**KIRKLEES METROPOLITAN COUNCIL
INVESTMENT & REGENERATION SERVICE**

**DELEGATED DECISION TO DETERMINE APPLICATIONS FOR
CONSENT, AGREEMENT OR APPROVAL REQUIRED BY CONDITION**

Reference No:	2025/44/91268/W
Site Address:	Land at, Penistone Road, Fenay Bridge, Huddersfield, HD8 0AW
Description:	Discharge of details reserved by conditions 17 (Retaining walls adjacent to highways), 25 (Boundary Treatments), 30 (Retaining Wall Materials) on permission 2022/93154 for erection of 68 dwellings with associated access, parking, open space, landscaping and infrastructure works (including installation of surface water attenuation tank)
Recommending Officer:	Katie Chew

Officer Report

| DRAWING TITLE:<br>1.8m Feather Edge Fence Detail                                                                                                                                          |                   |                    |                |

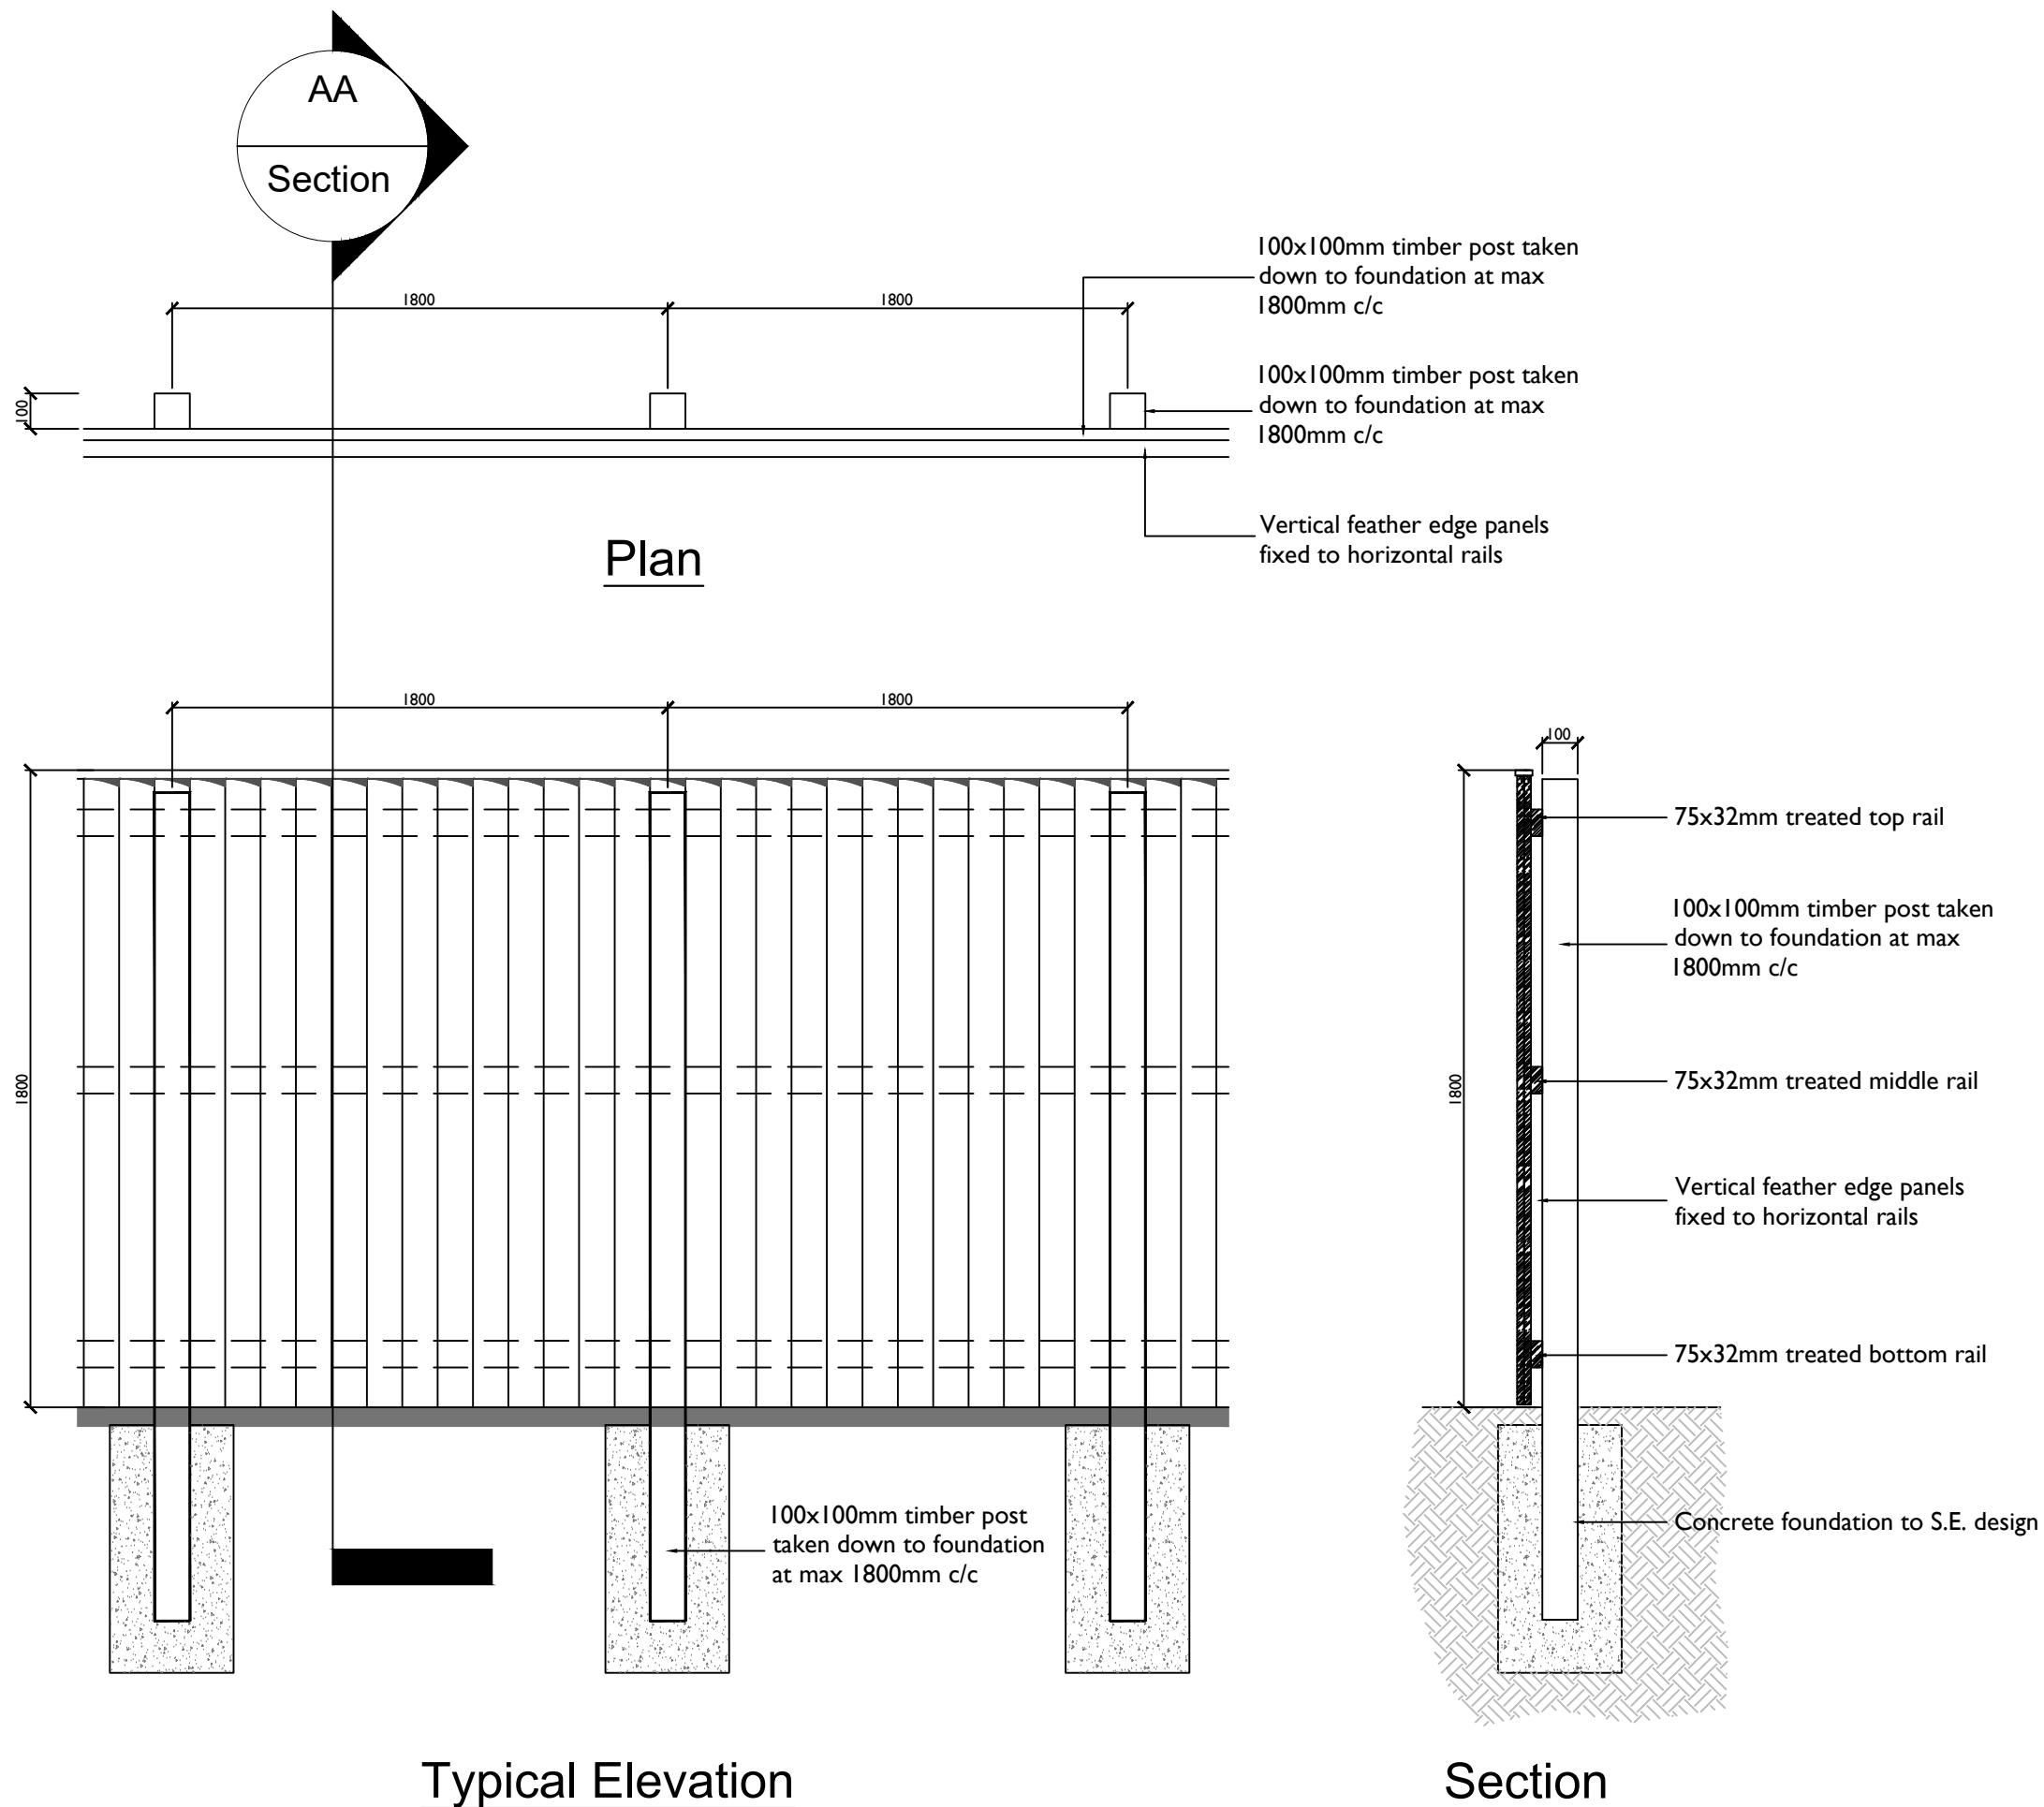
Boundary treatments such as the proposed 450mm timber knee rail and 2m acoustic timber fence are considered to be located in suitable areas within the site, be of an appropriate size and of a sympathetic material. The 1.8m feather edge fencing is also deemed as being an appropriate boundary treatment to the dwellings located within the estate.

Title: Sheet Pile Retaining Wall			
Contract: Fenay Bridge			
Client: Alfa Site Services			
DRG. STATUS: PRELIMINARY ISSUE			
Paper Size: A2	Scale: NTS	Designed By: OC	Checked By: AL
Internal Reference Number: 24219			Date: 07/11/24
Drawing Number: 24219-PS-XX-XX-DR-Y-0001			Issue: D

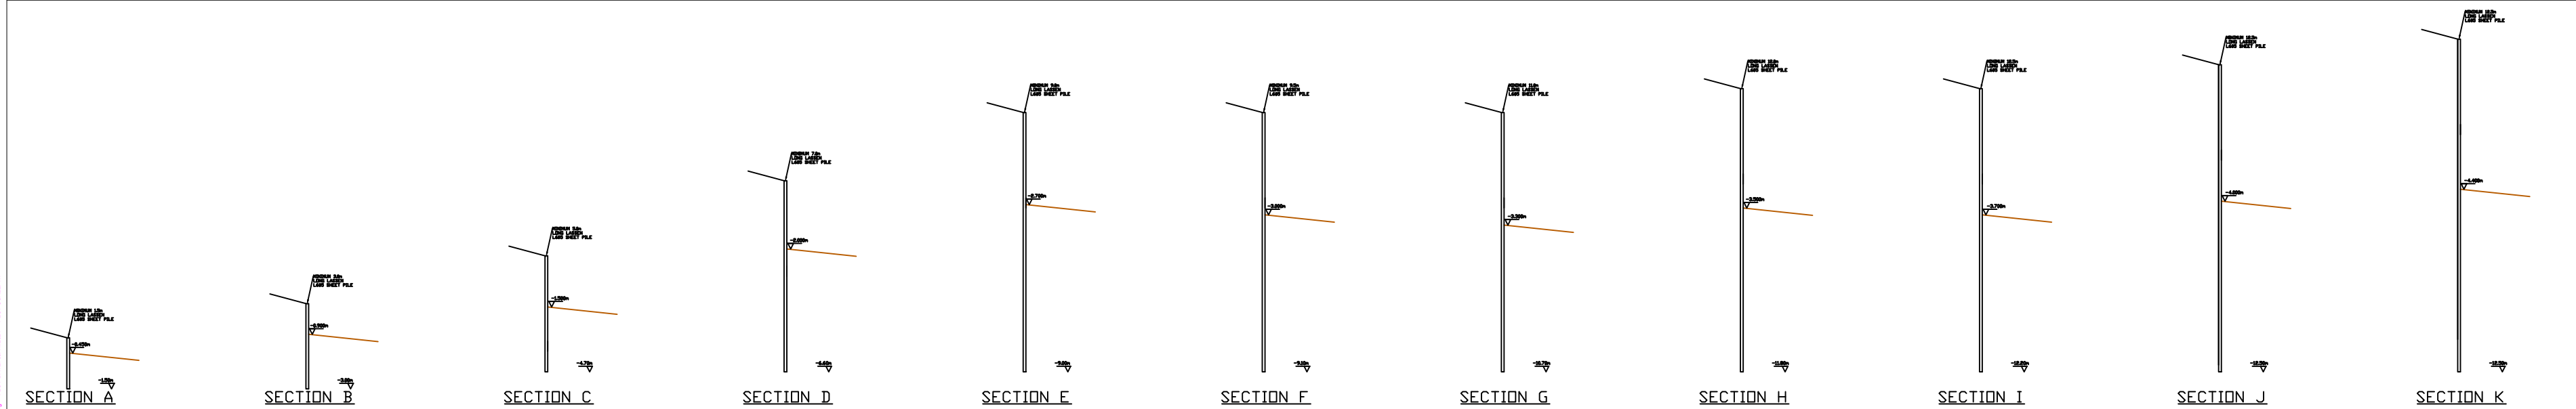
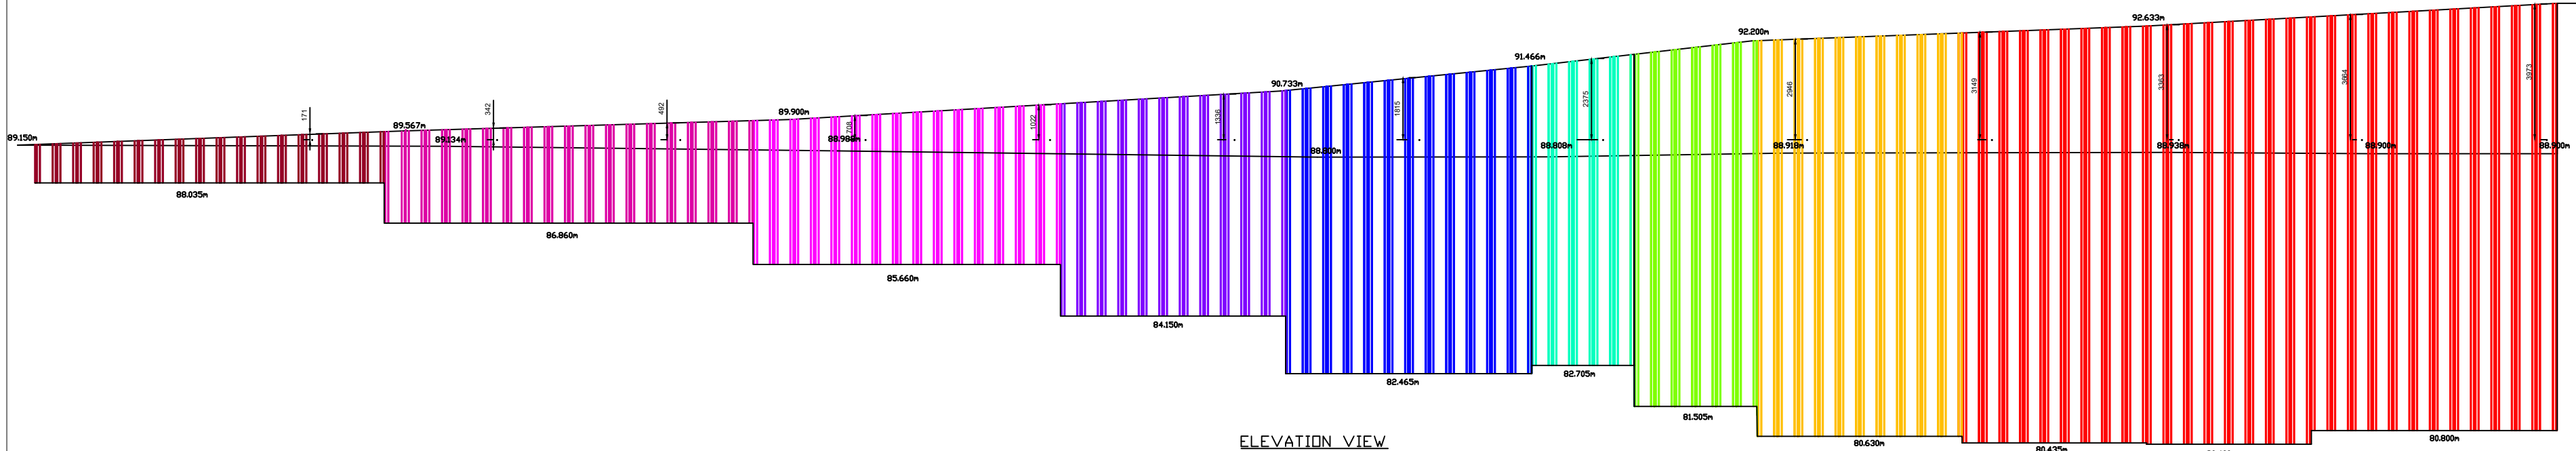
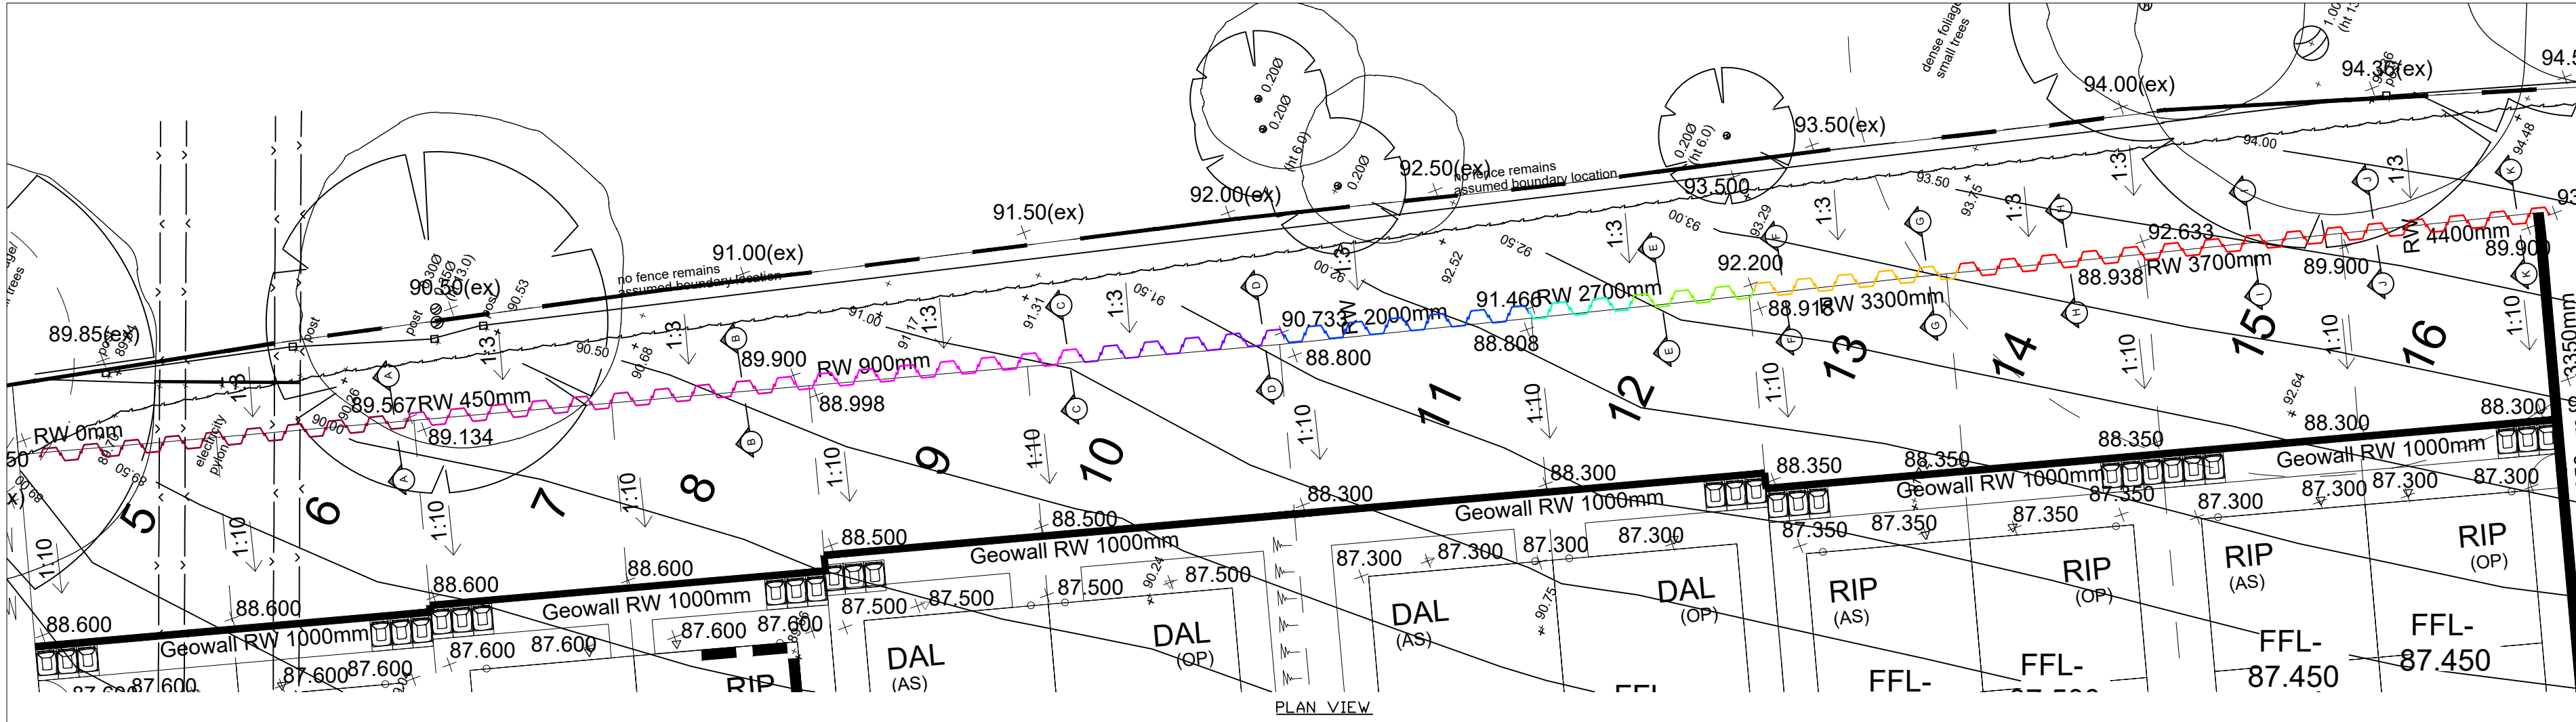
To the rear of plots 5 to 16 Sheet piling and 1800mm timber fence is proposed. The sheet piling is to be clad with Vertical feather edge Timber panels, above these panels is to be a 1.8-2.2m high hit and miss timber fence. Whilst this will in effect result in a the visual appearance of a fence upon a fence, and therefore has the potential to be overly dominant and monotonous, as these boundary treatments are to result in varied fence designs, this will help break up the visual façade of the boundary treatments, and therefore the proposed timber clad sheet piling and fence are considered to be acceptable on this occasion.
